Application number: 2023/90666	
What is the application for?:	Erection of two storey front and side extensions and erection of single and two
Address of the site or building:	New Barn, 23A, Strawberry Avenue, Liversedge, WF15 7NY
Postcode:	WF15 7NY

PROPOSED BLOCK PLAN
1:500

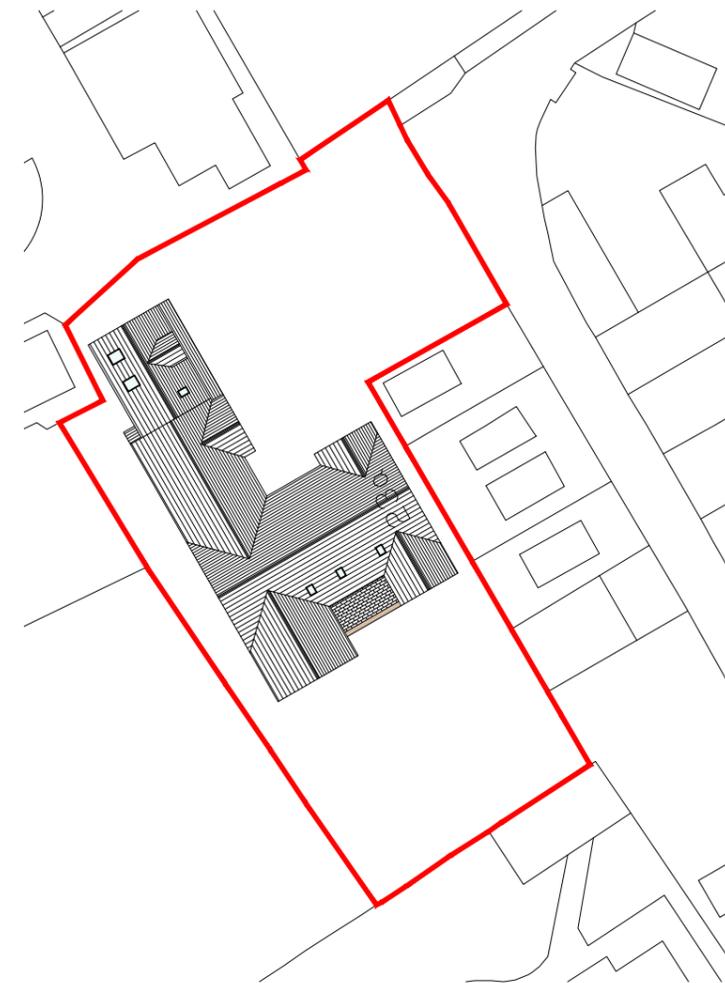
Type of comment: A general comment	
Do you wish your comments to be published on the website anonymously?	<input type="checkbox"/> Yes
the north end extention has a window over looking farm which we thought might be too close to boundry for our privacy. also the north side extentionis too close to boundry wall no room for scaffolding and too close to boundry wall for future maintanance. we thought may be 1000mm would be enough for scaffolding and future maintanance
